MMO Reference: DCO/2022/00015
Planning Inspectorate Reference: EN10131
Identification Number: GABE-SP022

Planning Act 2008 – Application by Gate Burton Energy Park Limited for an Order Granting Development Consent for the Gate Burton Energy Park

Deadline 5 Submission: Request for Further Information under Rule 17

Non-intrusive cable route cross section type B – River Trent

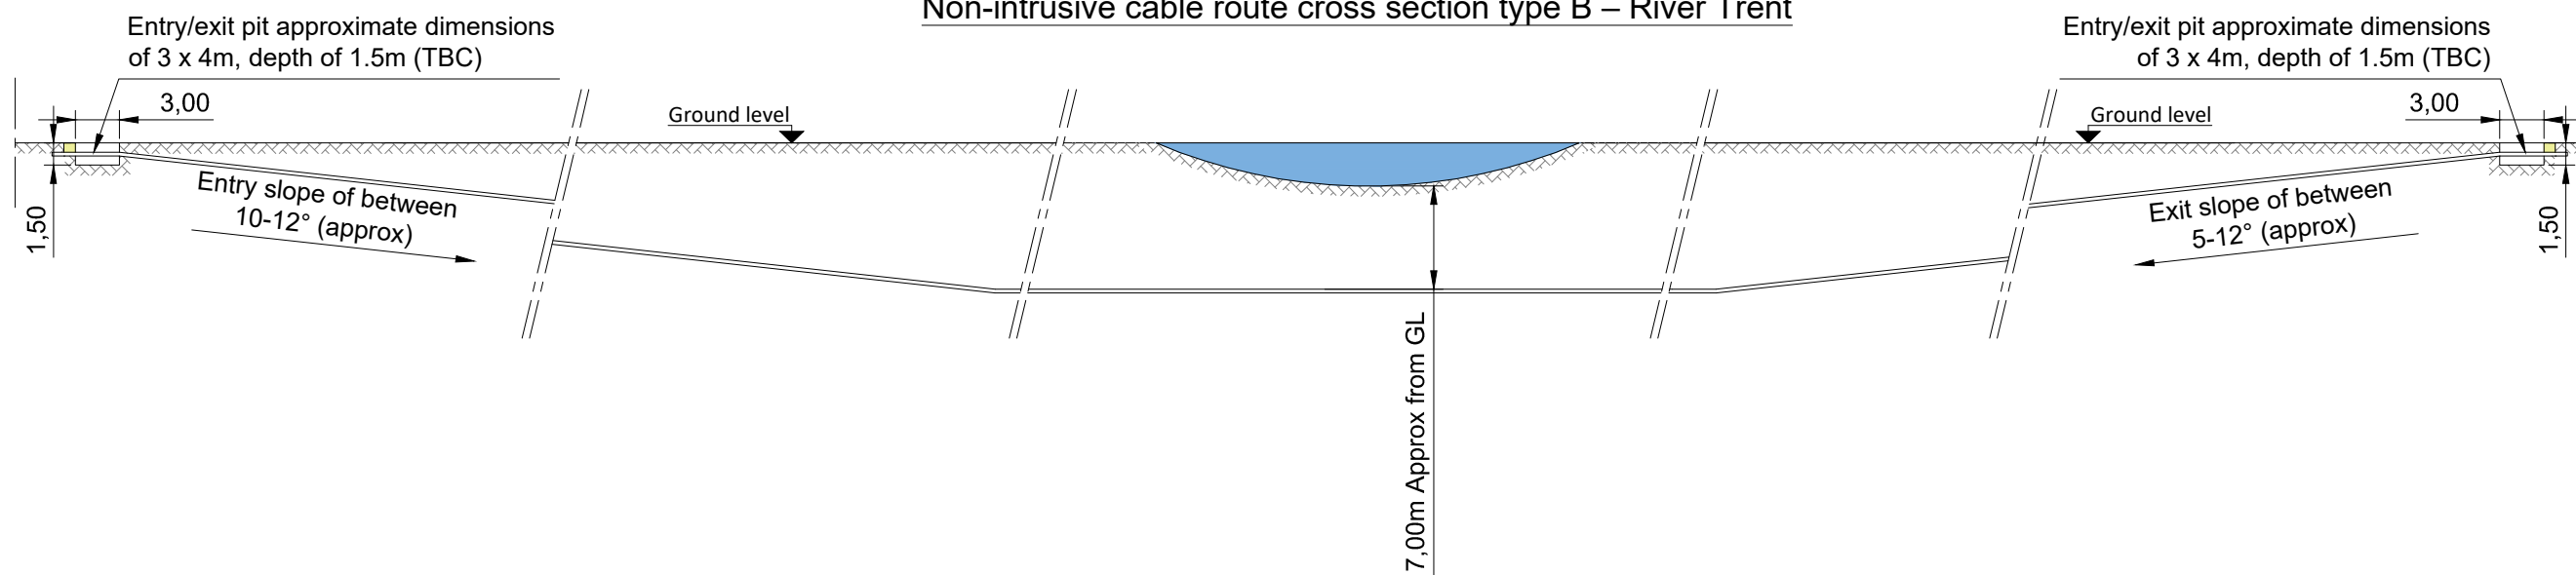
The MMO acknowledges the Applicant's submission of a Marine Environment Chapter at Deadline 4 in the Applicant Responses to Further Written Questions (Examining Authorities Questions 2) document [REP-046]. Within the Chapter the MMO notes the Applicant has stated the methodology of the drilling, or other trenchless techniques, would include measures to minimise the risk of the environment, and in addition, a site-specific hydraulic fracture (frac-out) risk assessment would be developed prior to construction following further site investigation. The MMO also recognises the HDD depth is now a minimum of 5 metres (m) below the lowest surveyed point of the riverbed.

However, the MMO is unable to find any further mention to a scenario regarding possible problems arising during construction or operation. Therefore, the MMO has not been able to review and consult on the scenario detailed above. As requested in our Deadline 4 response, the MMO welcomes the inclusion of a methodology showing the worst-case scenario and would comment on this accordingly.

If such interventions are required, the MMO request that the DML be updated to include further description of the required activities as set out in Section 66 of the 2009 Act. The DML does not currently include the worst case scenario and this would enable the MMO to gain a better understanding of the licensable activities that are included in the DML.

As previously mentioned, the MMO require worst case scenario details within the methodology, in order that it can assess the potential problems and issues and what this may entail with regards to the necessity for a DML.

Upon receipt of specific details, including, for example, how the drill head would be retrieved and what equipment would be used, and following any required consultation, the MMO will be able to provide further comments on the sorts of conditions that may be required.
